From: Martyn White
Sent: 24 June 2019 10:20
To: Amber Willard <Amber.Willard@arun.gov.uk>
Cc: Planning.Responses <Planning.Responses@arun.gov.uk>
Subject: WA/36/19/HH & WA/37/19/L

WA/36/19/HH & WA/37/19/L

Holly Tree Cottage is a Grade II Listed Building which is also located within the Walberton Village Conservation Area.

The application is for the provision of a first floor rear extension, along with a new detached car port/garage structure to be located within the front garden area, to the side of the property. I provide my comments on both elements of the proposal separately.

Proposed Roof Plan at 1:100 scale

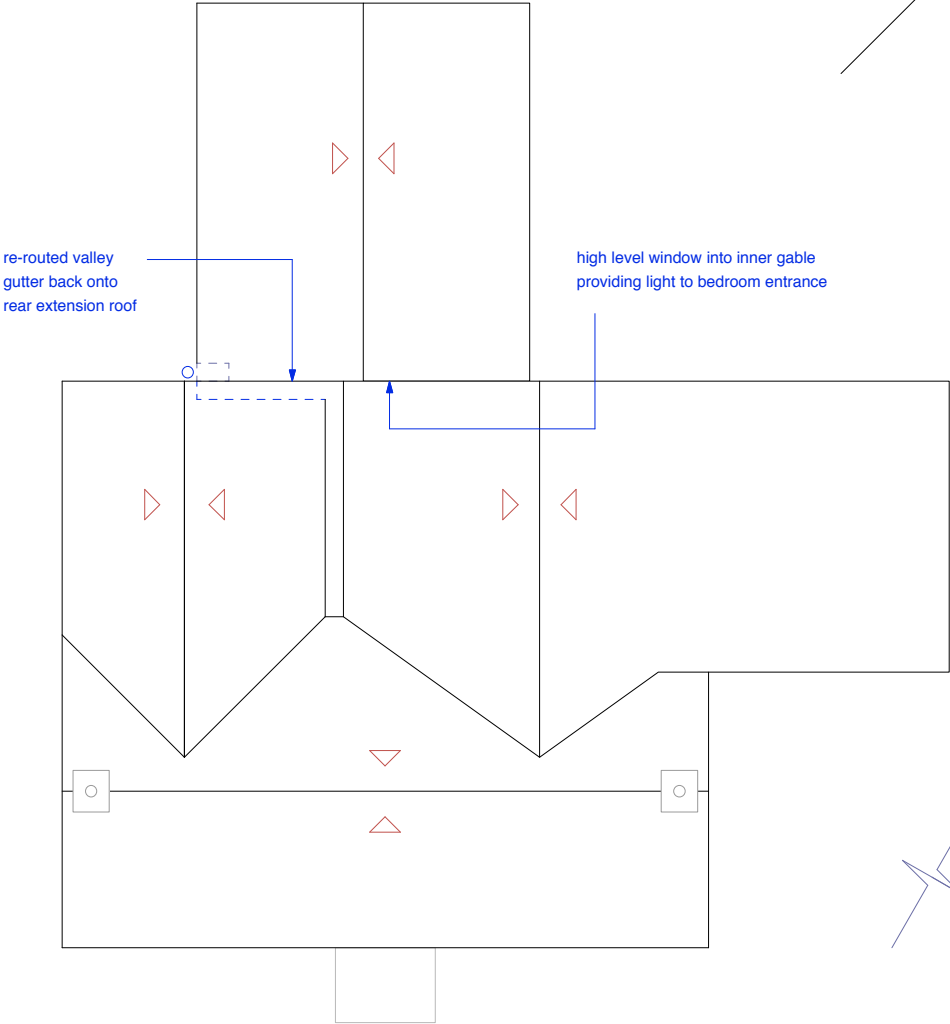
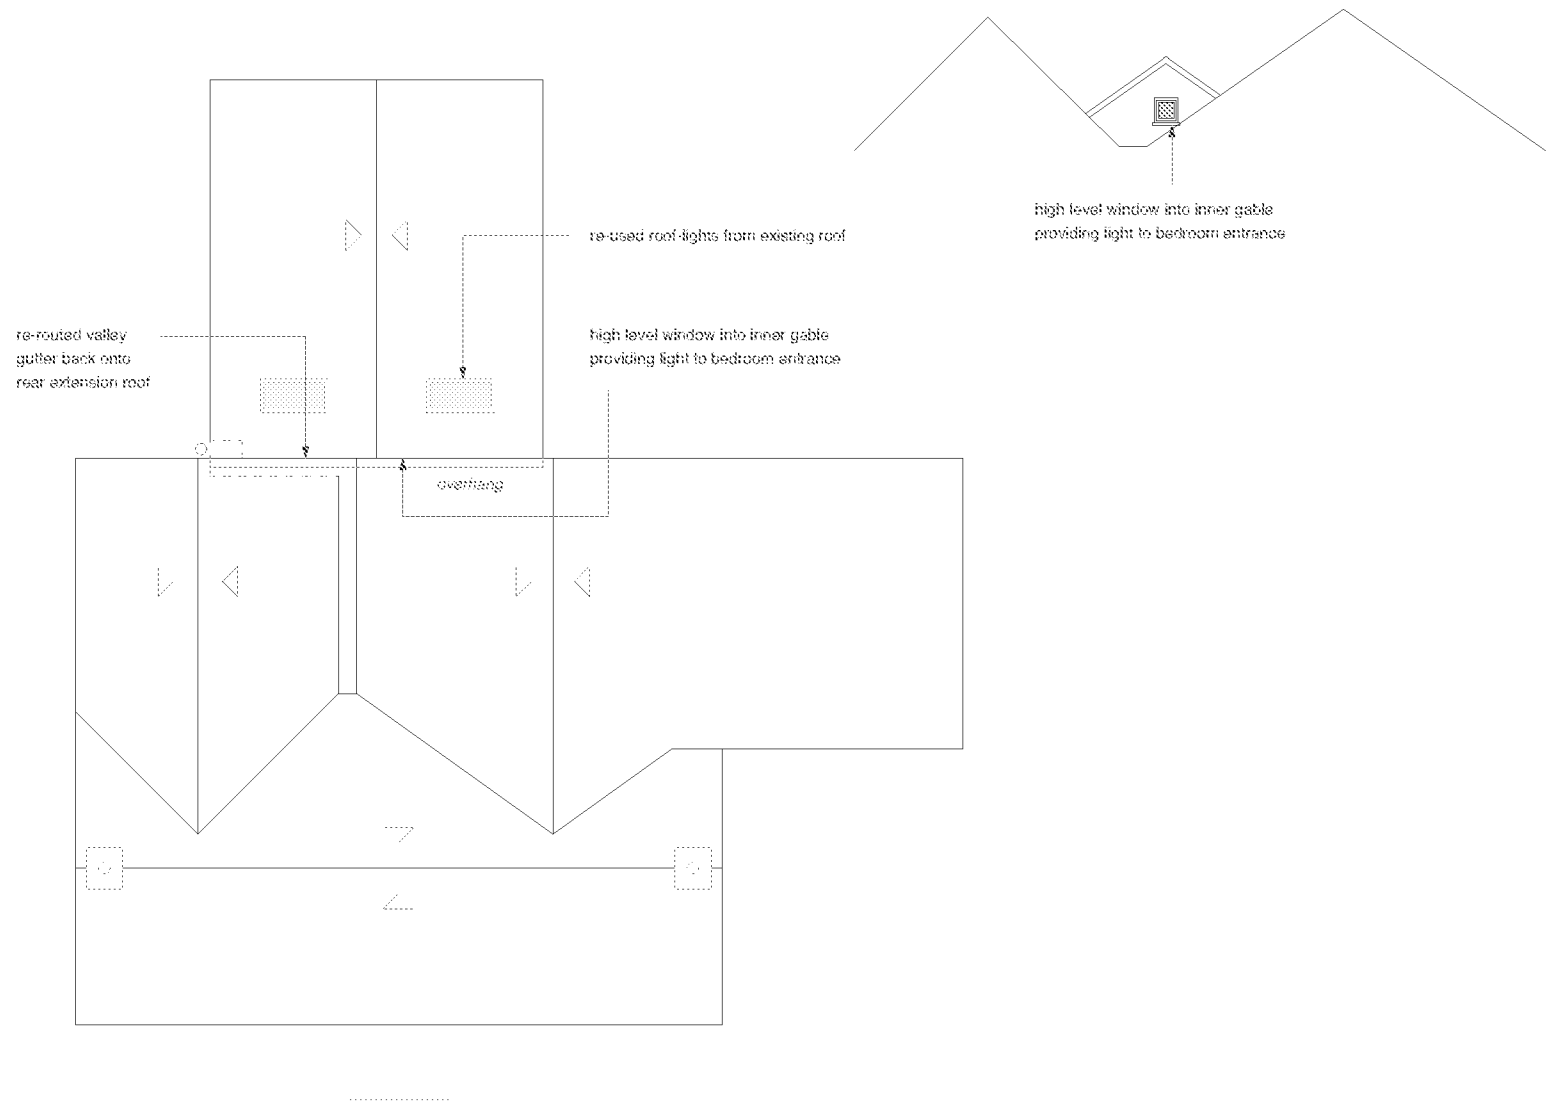
The extension would be sizeable and increase the mass of the existing modern extension. It does not look so be much smaller than the previously withdrawn applications

The current proposal involves the gable end of the proposed first floor extension being below the height of the two historic gables at the rear of the building. This allows for it to read as somewhat subservient to the older parts of the building.

The use of a gable end at first floor level is considered to be acceptable as this is consistent with the use of other gables at the sides and end of the building.

Proposed Plan at 1:100 scale

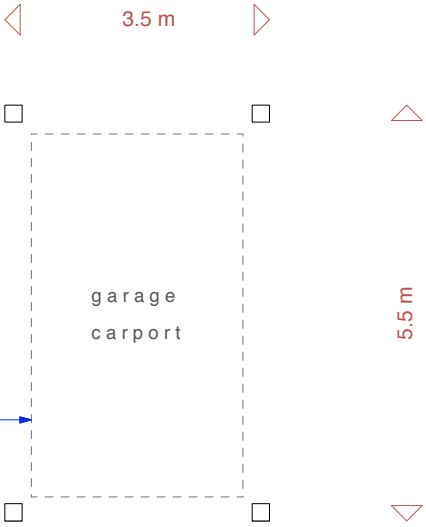
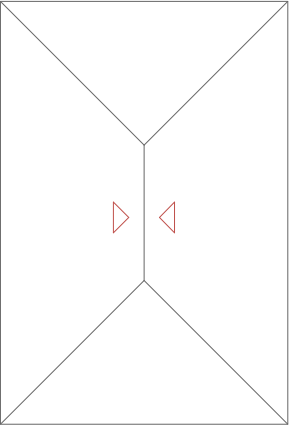
The proposed carport would essentially project forward of the front elevation of the cottage on part of the existing parking area. At present the front garden area is contained by the flint wall and mostly laid to lawn with a small parking area for the resident's private car. Therefore, at present the cottage is fully visible from the street, and forms a focal point.

Development of the garage in this particular location will mean that it will play a dominant role in the street-scene and partially block views of the listed cottage, so that only part of it is visible when looking westwards.

Further, it would be the only structure of this design, in this location in the conservation area.

Proposed First Floor Plan at 1:100 scale

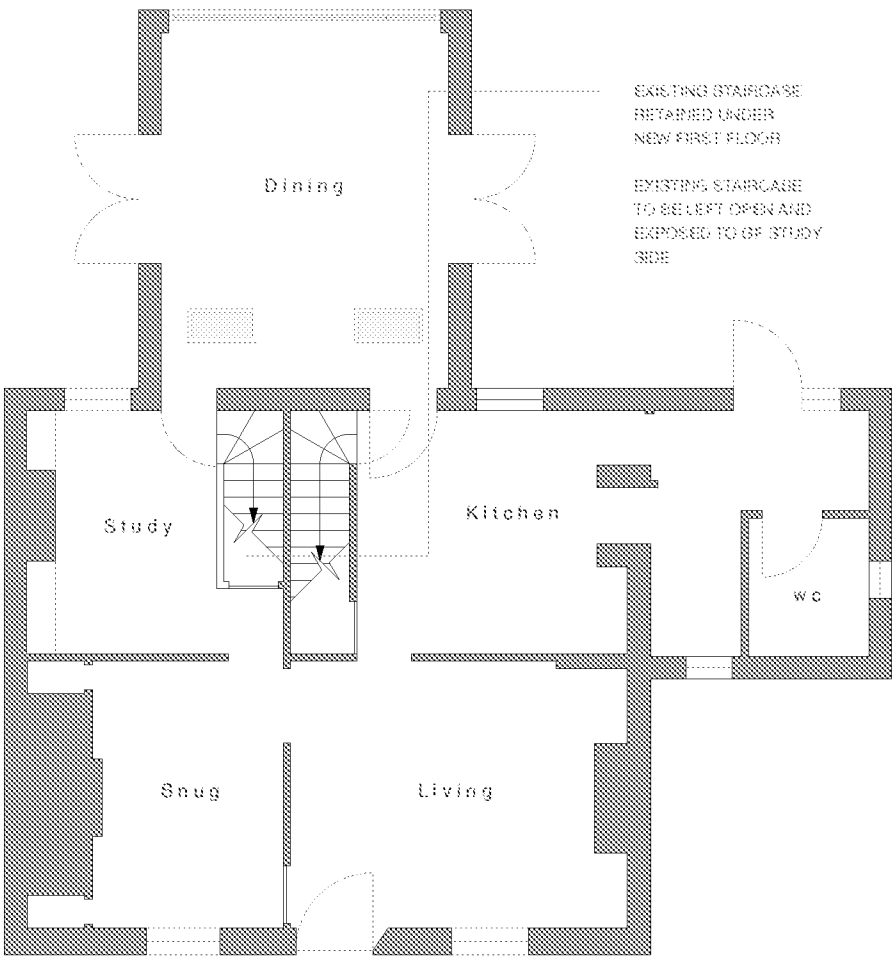
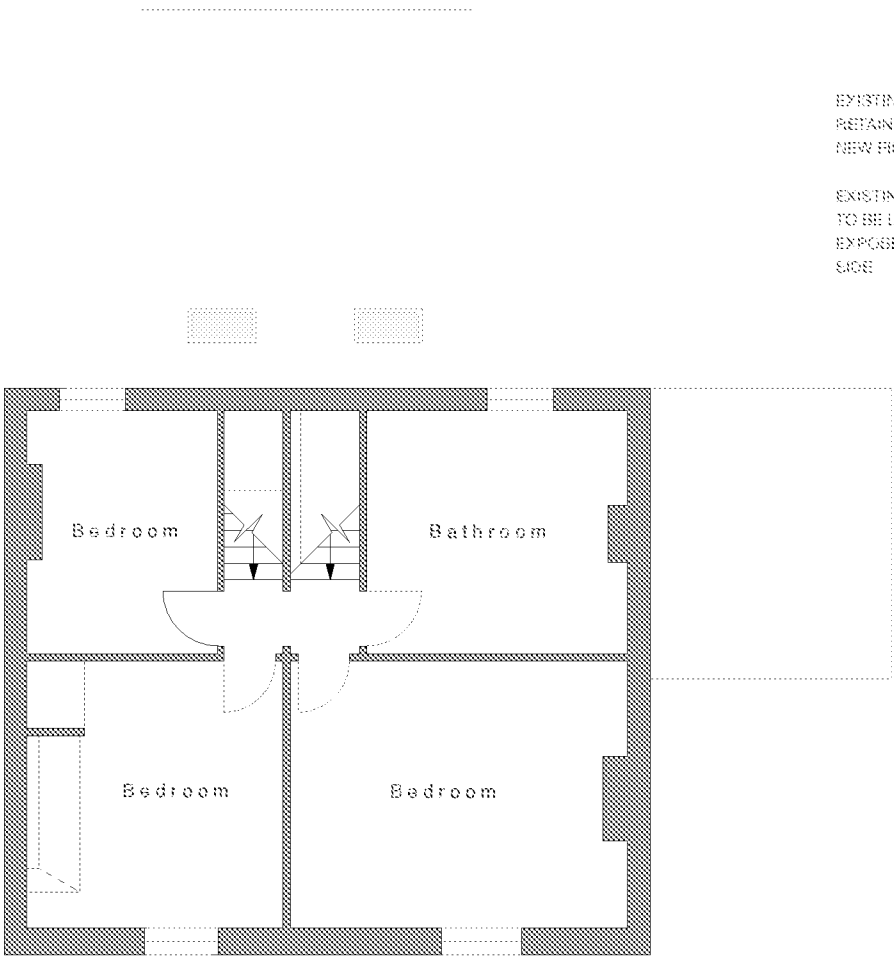
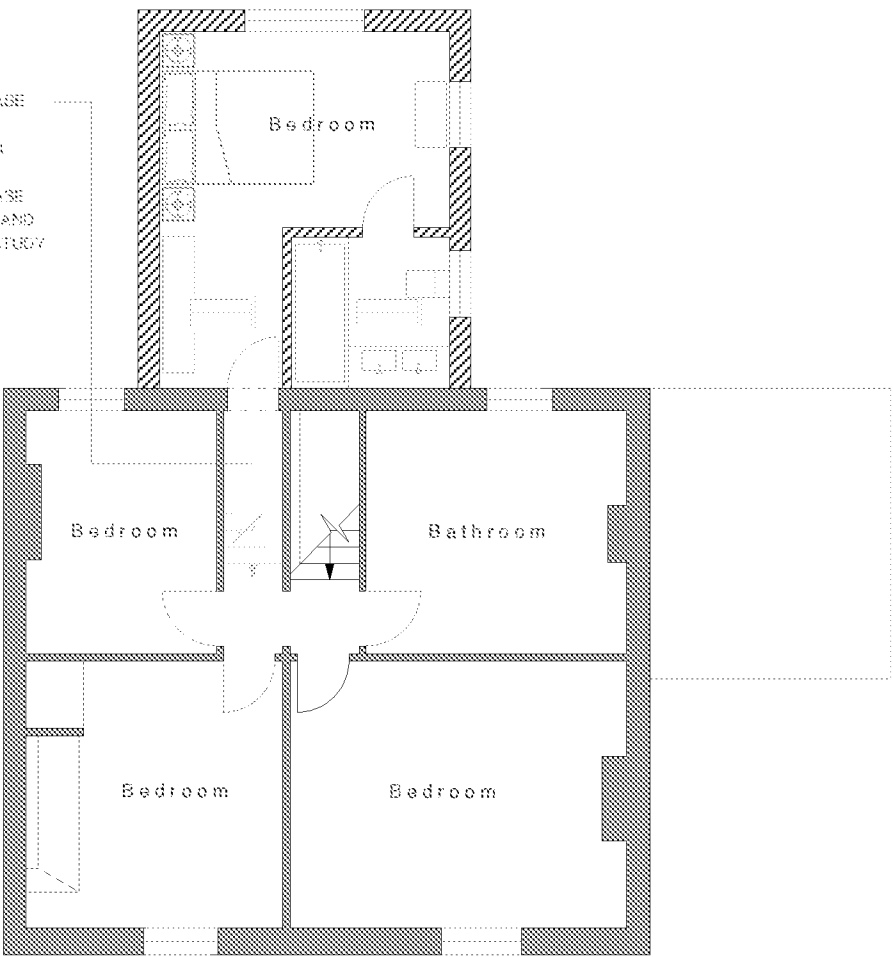
The proposal will involve the loss of one of the existing staircases, which has been identified in the heritage information as being linked to the time when the house was two properties. No further information has been provided regarding the staircase to be removed, or an assessment made on the significance of the structure, nor the impact of its loss. At the moment, it has to be considered that this element of the proposal would result in the loss of historic fabric, remove an element of the properties historic development and could therefore harm the significance of the cottage.
